To: BotleyWestSolar@planninginspectorate.gov.uk
Project: Botley West Solar Farm Application EN010142
Interested party ref. [REDACTED]

Botley West Solar Farm: EN010147

Area of major concern posed by the new submissions

Figure 5 - Illustrative Masterplan

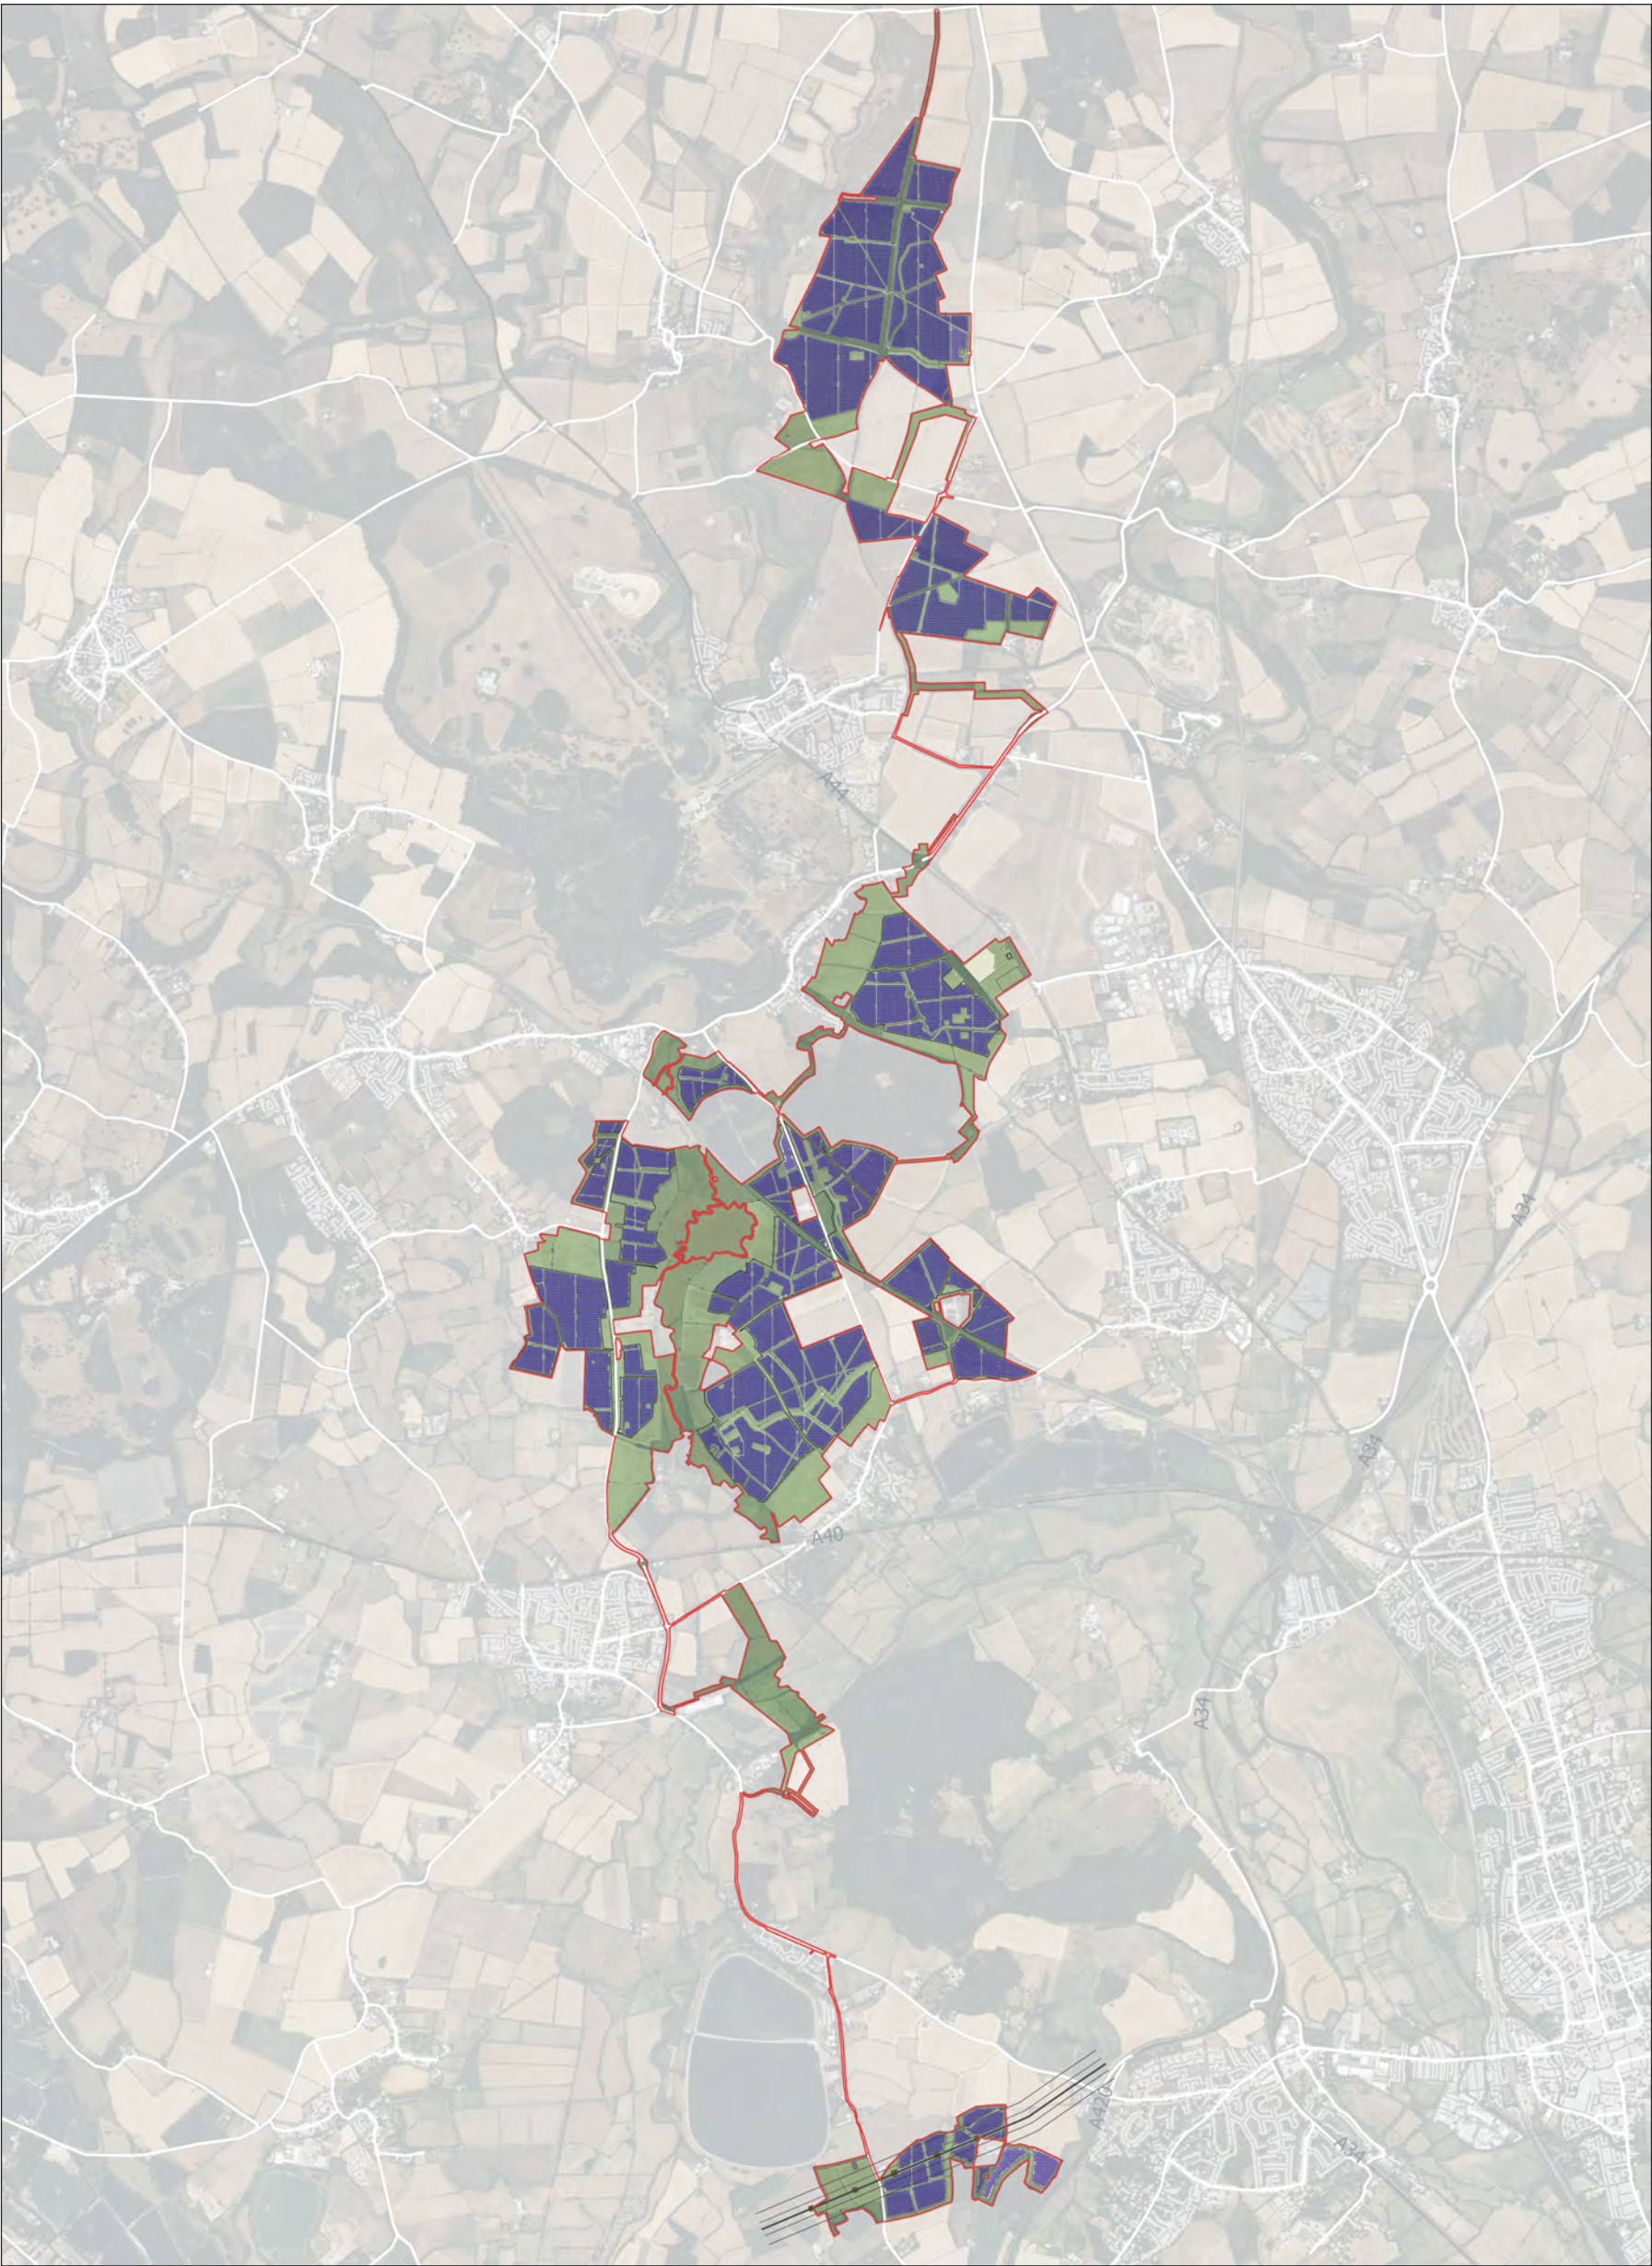
A huge concern is the introduction of an "outline Residential Visual Amenity Plan" (oRAP) [[C1-108](#)] and new Masterplan revision 5 [[C1-111](#)] in which the default buffer zone now offered and drawn is 100m (compared with the 250m default recommended by the Examiners and previously shown in the Applicant's 9 June masterplan revision 4 [[C1-051](#)] "with additional offsets up to 250m applied where needed". It is unclear how this "need" would be assessed post-consent when it will be beyond public scrutiny. This directly affects the residential visual amenity of our residence, along with many others.

- **Proposed cycle path along Lower Rd** still shown on Masterplan despite verbal agreement to remove from the Application (during the Examiners' Site Inspection on 7 October 20).
